**Consultation Response from KC,
Highways Development Management**

2024/90956 Globe Mills, Bridge Street, Slaithwaite, HD7 5JN

**Conversion of existing mill building to multi-storey car park, erection of external stair and lift
cores with associated landscape and access arrangements (within a Conservation Area)**

Date Responded: 19/03/2025

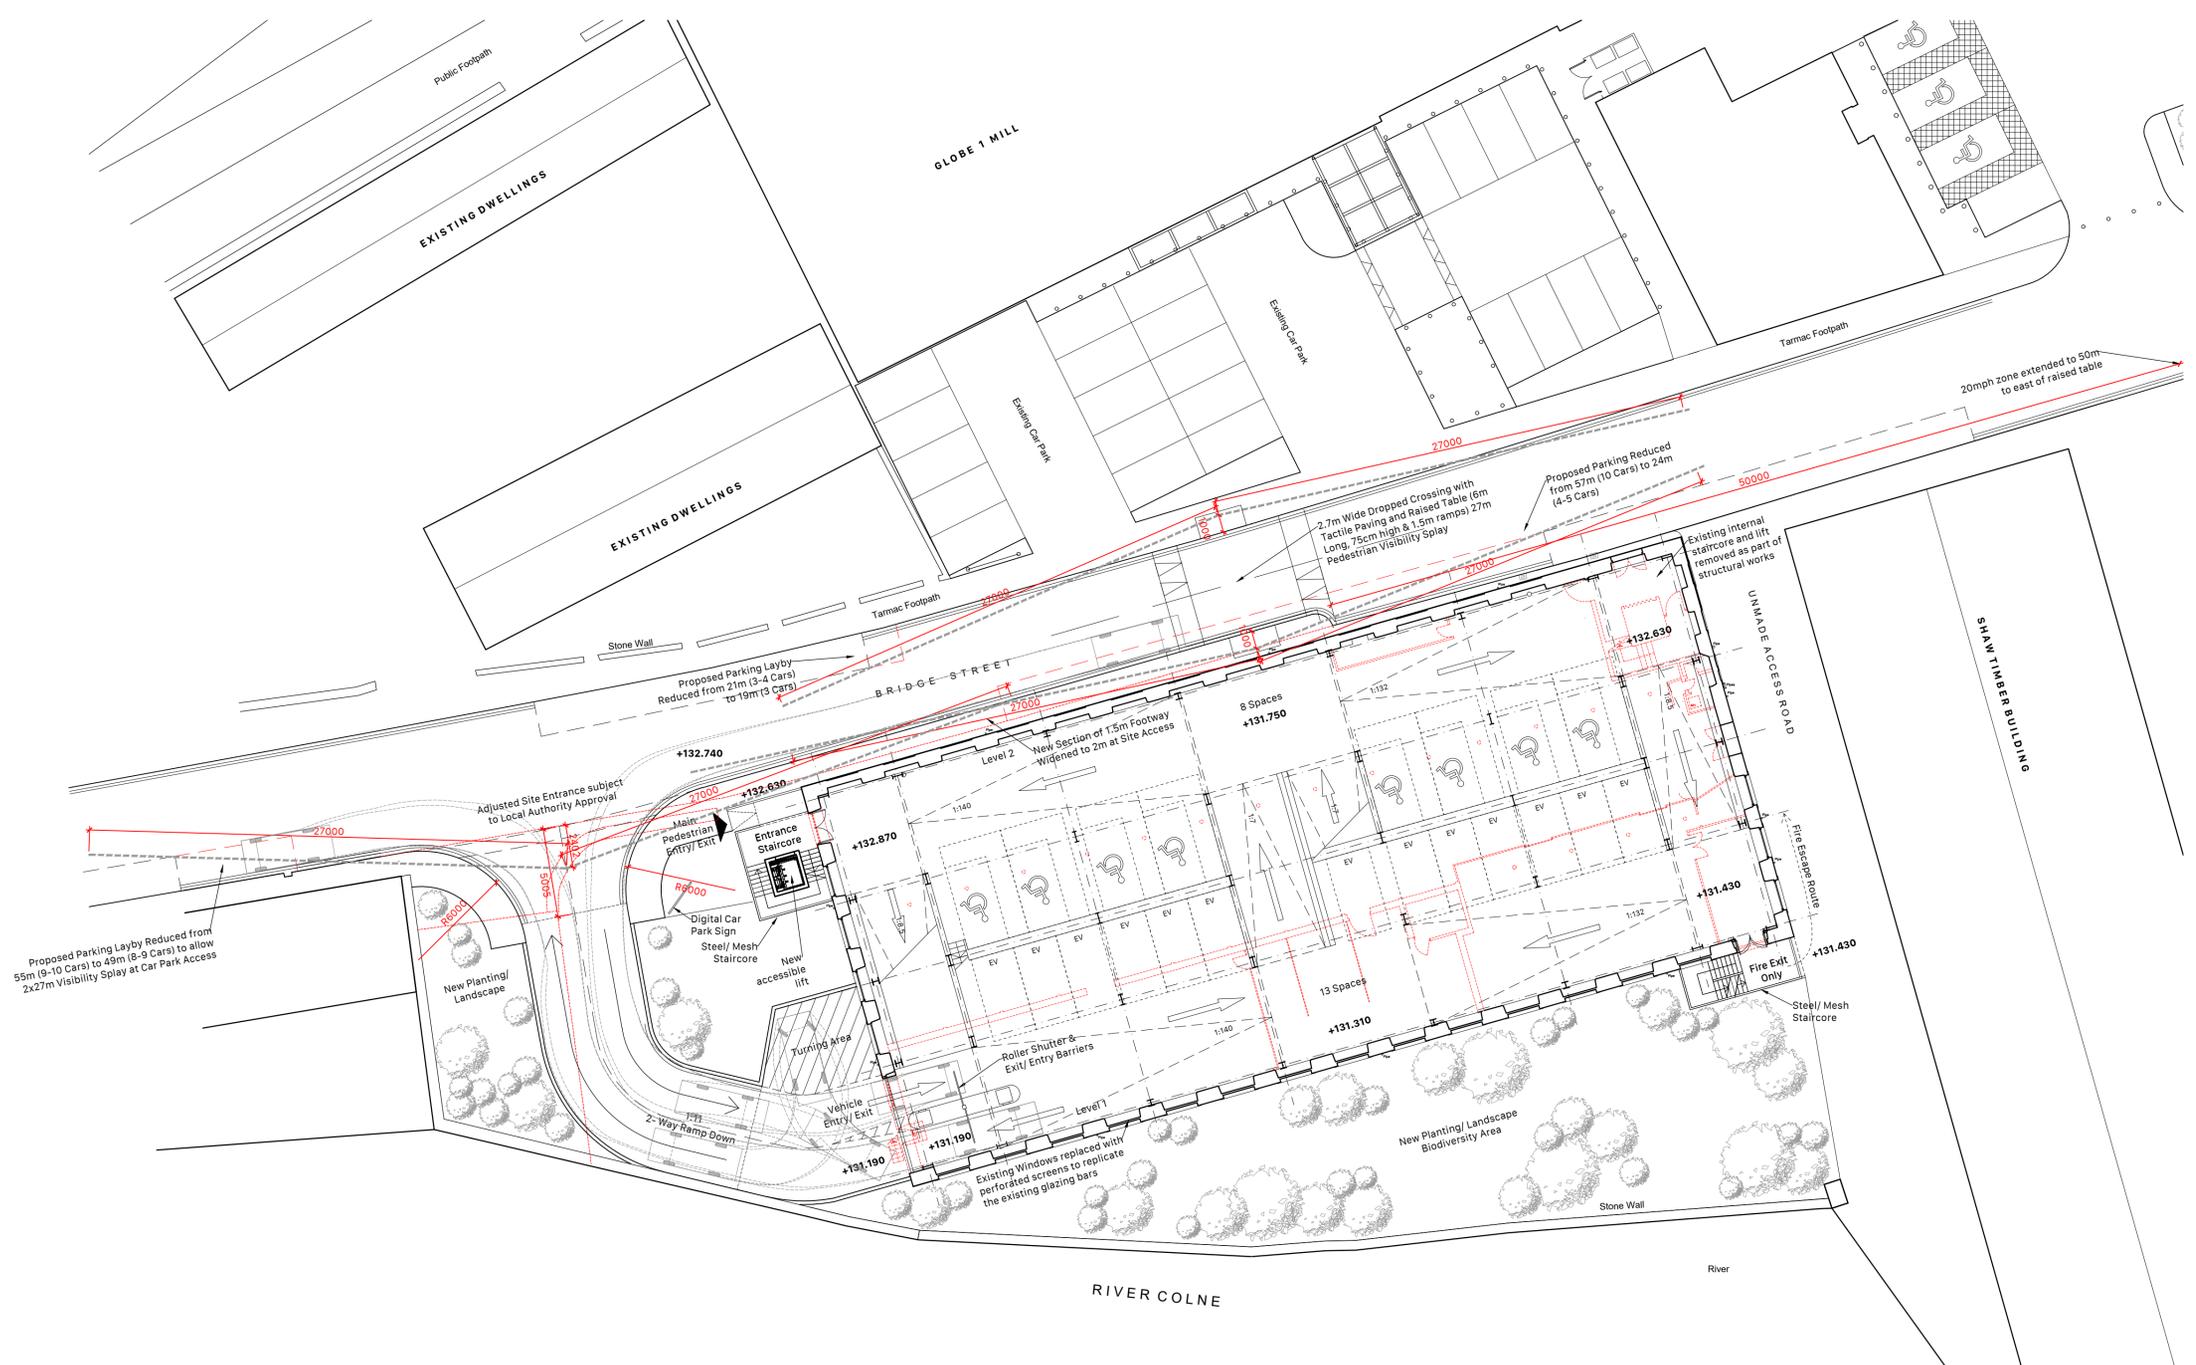
These comments are based on the revisions to the access and changes to the TRO scheme and associated highways works as indicated on drawing No 333.19(1-)005 Rev I and the Stage 1 Road Safety Audit (RSA) provided by the applicant.

The highway works proposed (and shown on drawing No 333.19(1-)005 Rev I) should be funded by the developer and carried out within a s278 agreement and include amendments to the parking TROs on Bridge Street, changes to the speed limit, the construction of a raised table and pedestrian footway.

The amended access is shown on drawing No 333.19(1-)-005 Rev I and is acceptable.

Prior to occupation of the development, the off-site highway works as shown on plan Drg No. 333.19(1-)005 Rev I comprising amendments to the TRO parking restrictions, changes to the speed limit, the construction of a raised table and the construction of a pedestrian footway on Bridge Street shall be fully constructed and made operational.

Means of access to and from the site shall be in accordance with the preliminary access design as shown on the approved plan, Drawing No. 333.19(1-)005 Rev. I, and fully constructed and made operational prior to first occupation of the development and thereafter retained and maintained for the lifetime of the development.

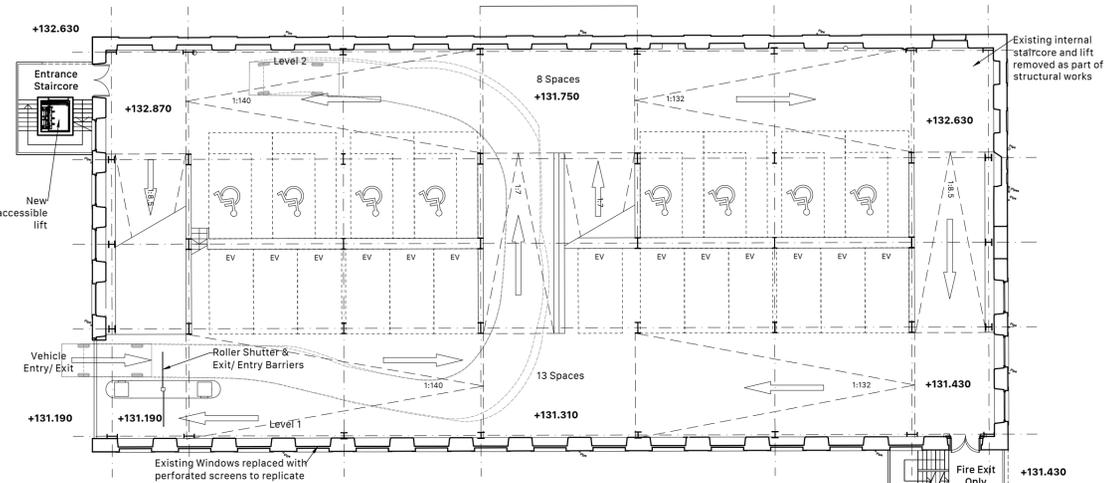
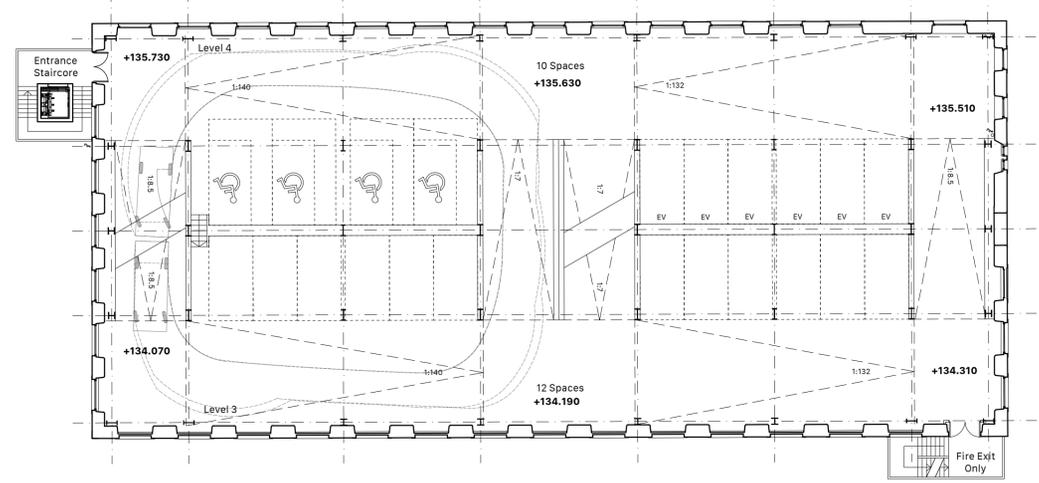
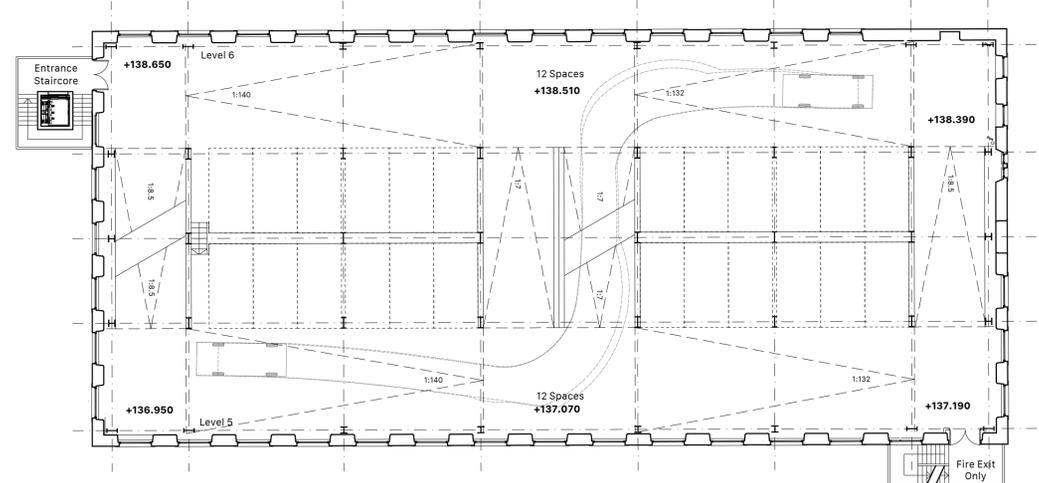
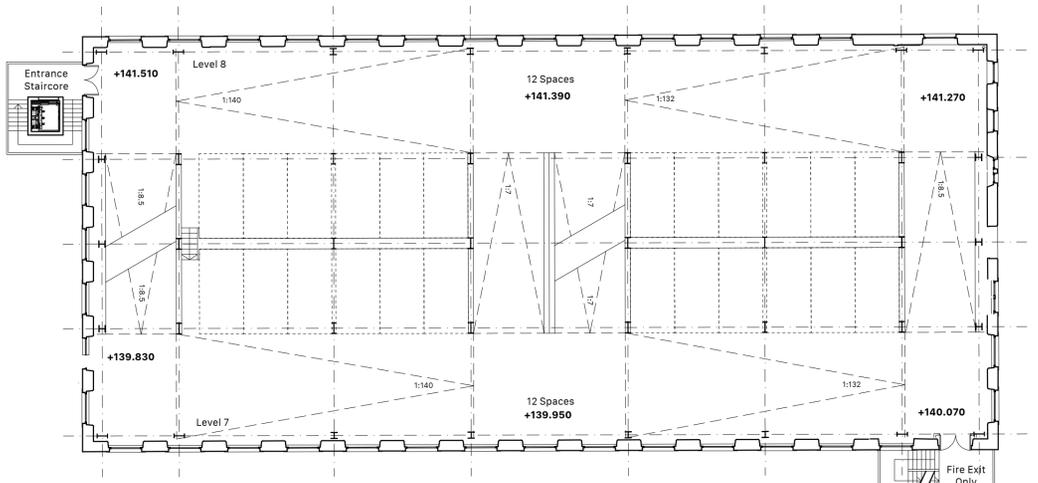
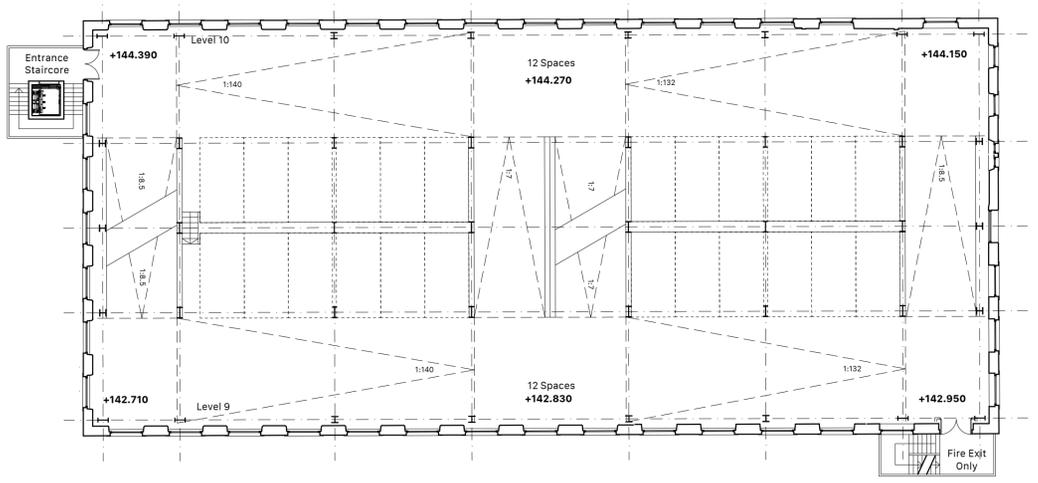
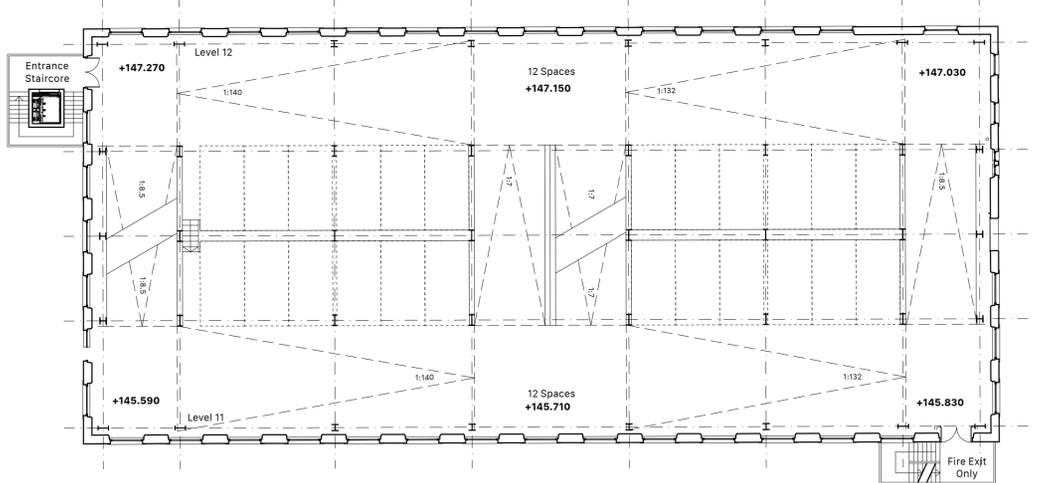
This is shown on revised drawing No drawing No 333.19(1-)-006 Rev C. This loses some parking spaces from the original design but has improved the vehicle circulation within the car park with the formation of a one-way system and additional up/down ramps. This removes the need for turning spaces on the upper floors and removes an element of possible conflict by removing the two-way circulation system. The revised one-way circulatory system should be backed up with clear arrow markings and signs indicating routes upwards and the exit route downwards with clear no entry signs to avoid cars accidentally driving the wrong way around the car park.

The internal ramps have a gradient of approximately 1:7 and a width of approximately 4m and this is acceptable.
